RFI

RFI #: 28
Date: 1/5/2012
Job: EB-02 Keller Springs Lofts
Phone: 877-777-5115

Subject: Pit detail

Drawing: SG2.01 & 5/SG3.02
Cost Impact: None

TYPICAL PIT WALL SECTION
NO SCALE

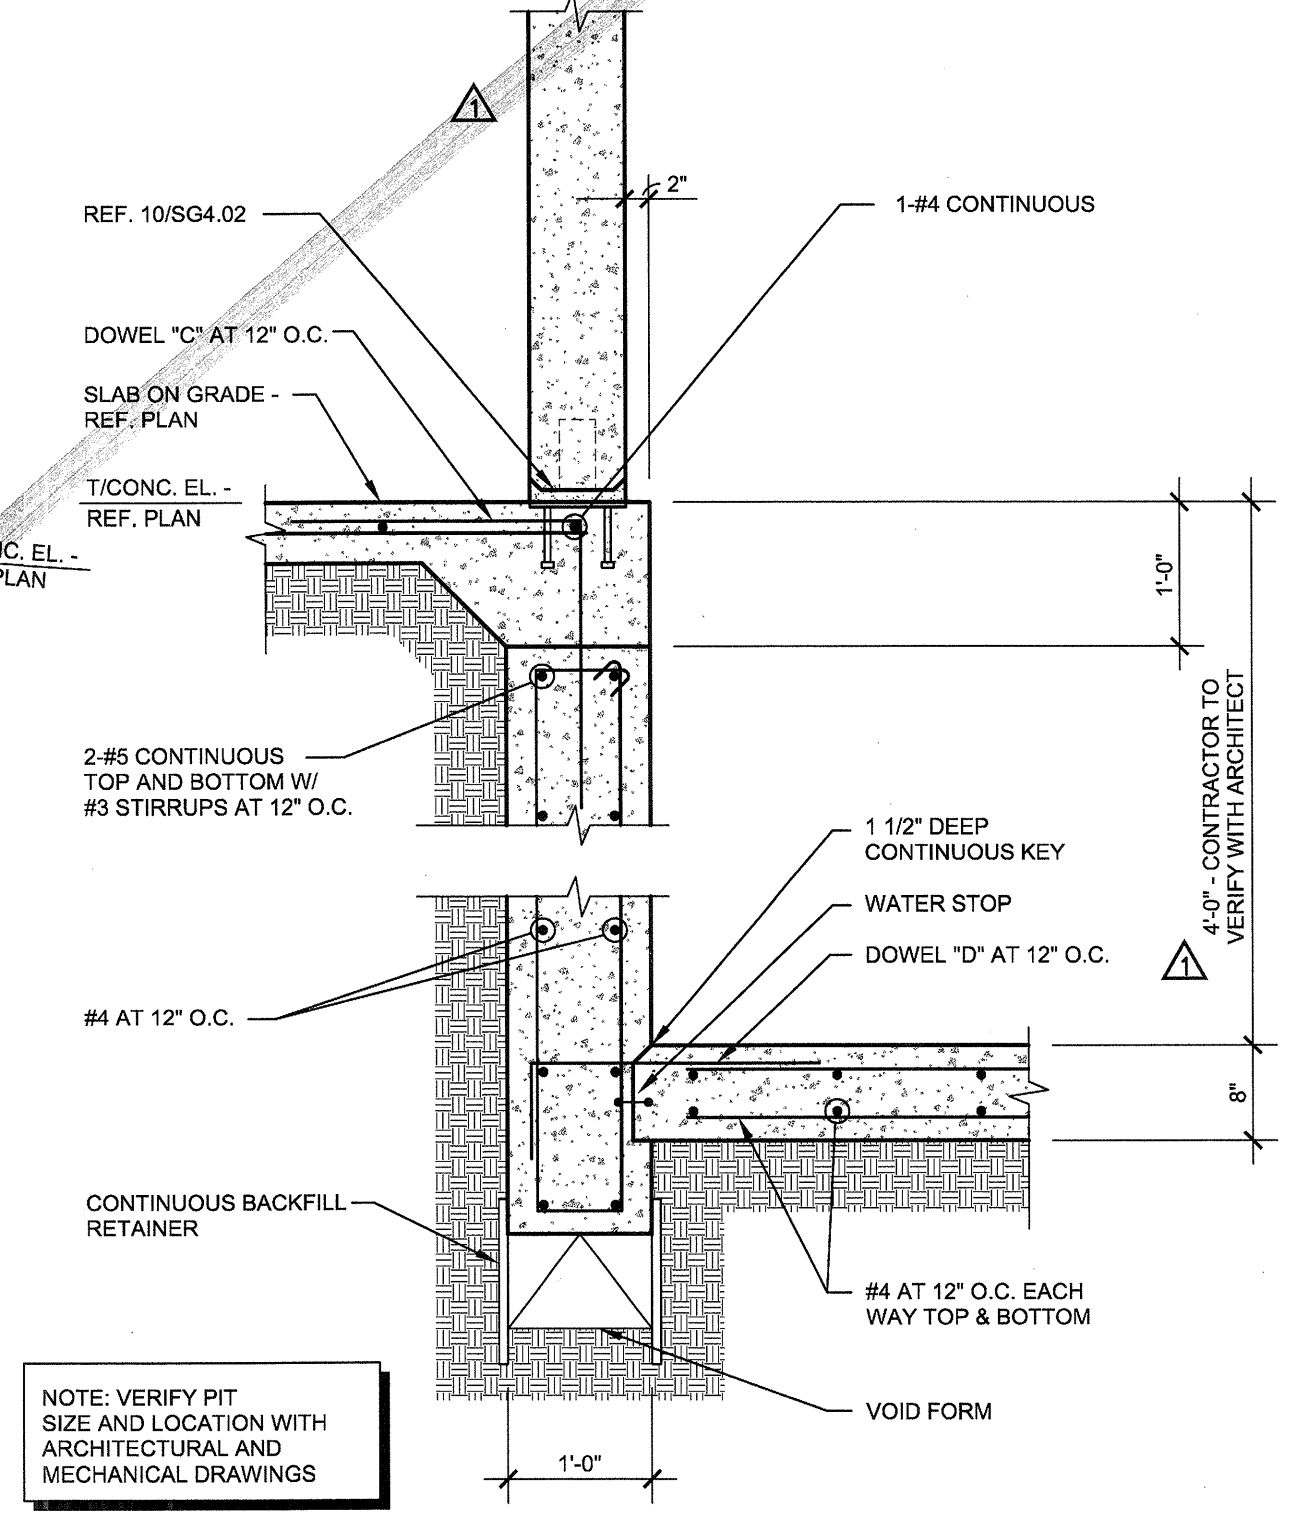
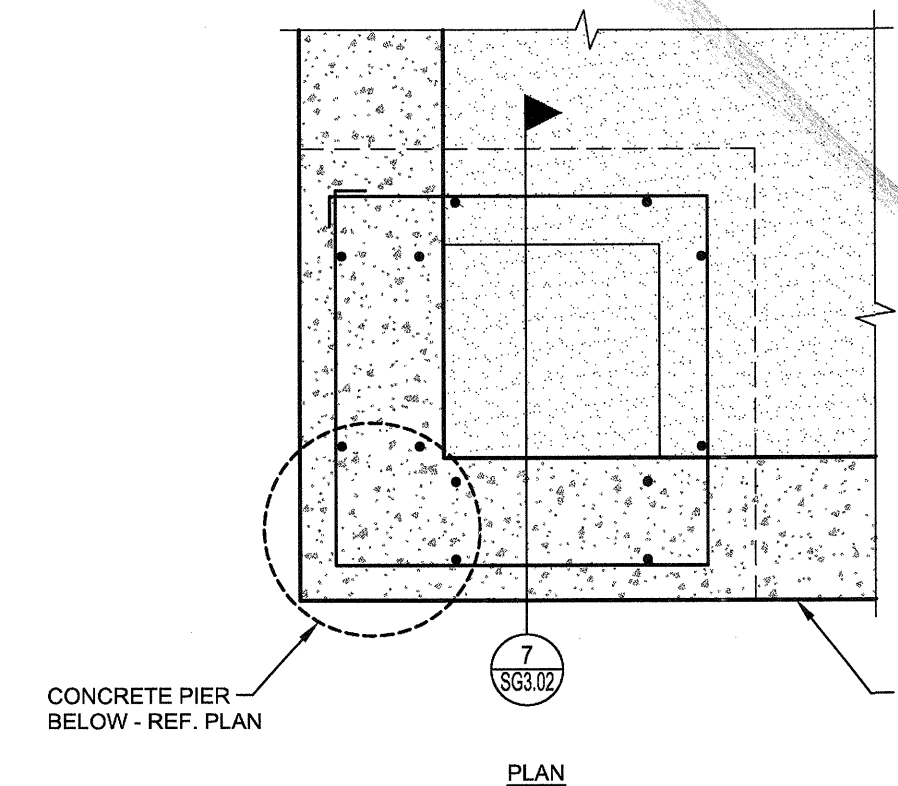
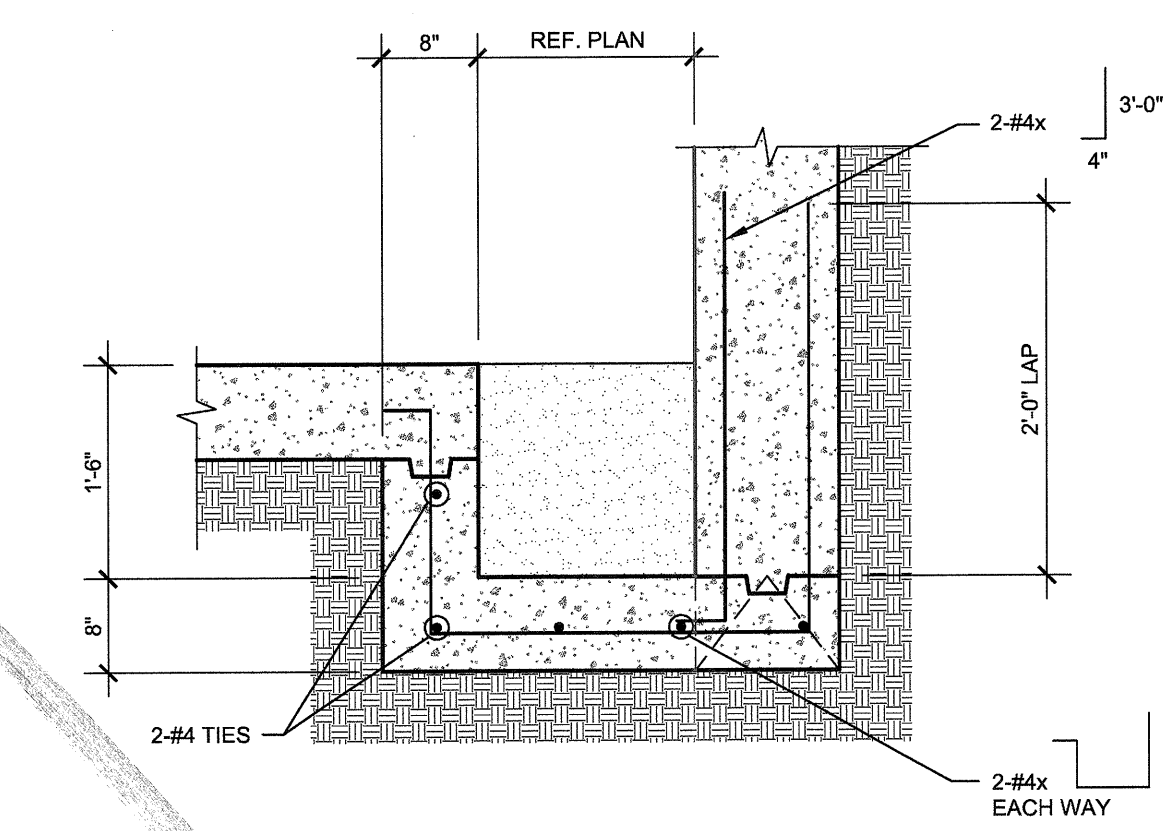
Request: Date Required: 1/12/2012
On sheet Sg2.01 we have a cut through 5/SG3.02 show a pit detail at ventilation shaft. What pit and Why? Please advise

Please refer to revised drawings issued on January 25, 2012. If you have questions or require additional information regarding this matter, please do not hesitate to contact us.
